3 February 2026

The Secretary  
NSW Department of Planning, Housing and Infrastructure

**SSD-77458970 Mixed-use residential and commercial development - 135  
Badgerys Creek Road**

**DRAWING TITLE**  
GENERAL FLOOR PLAN - GROUND 00

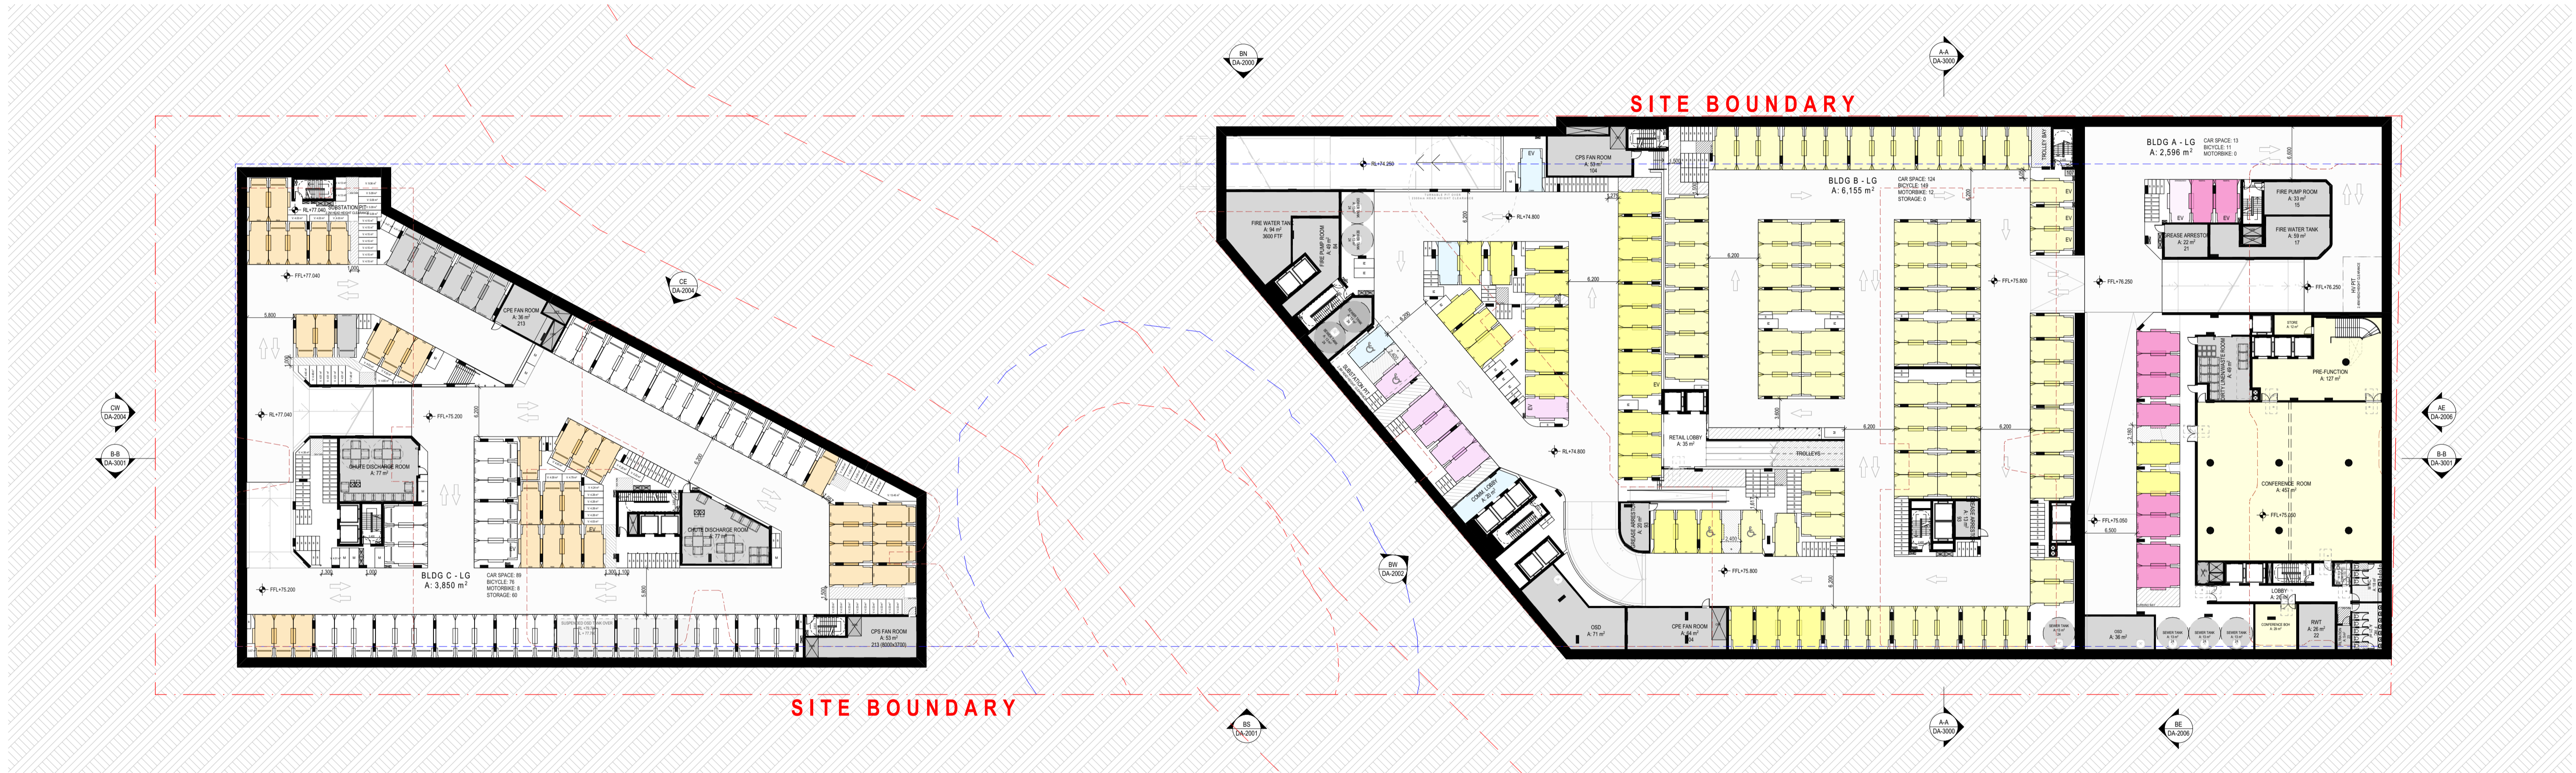
The below copy of the General Floor Plan – Ground shows provision for three indoor substations. Any required distribution substations will need to be located within the property (in a suitable and accessible location) and be protected (including any associated cabling not located within a public road / reserve) with an appropriate form of property tenure as detailed in the attached copy of Endeavour Energy's 'Land Interest Guidelines for Network Connection'.

Generally it is the Level 3 ASP's responsibility (engaged by the developer) to make sure substation location and design complies with Endeavour Energy's standards the suitability of access, safety clearances, fire ratings, flooding etc. If the substation does not comply with Endeavour Energy's standards, the applicant must request a dispensation.
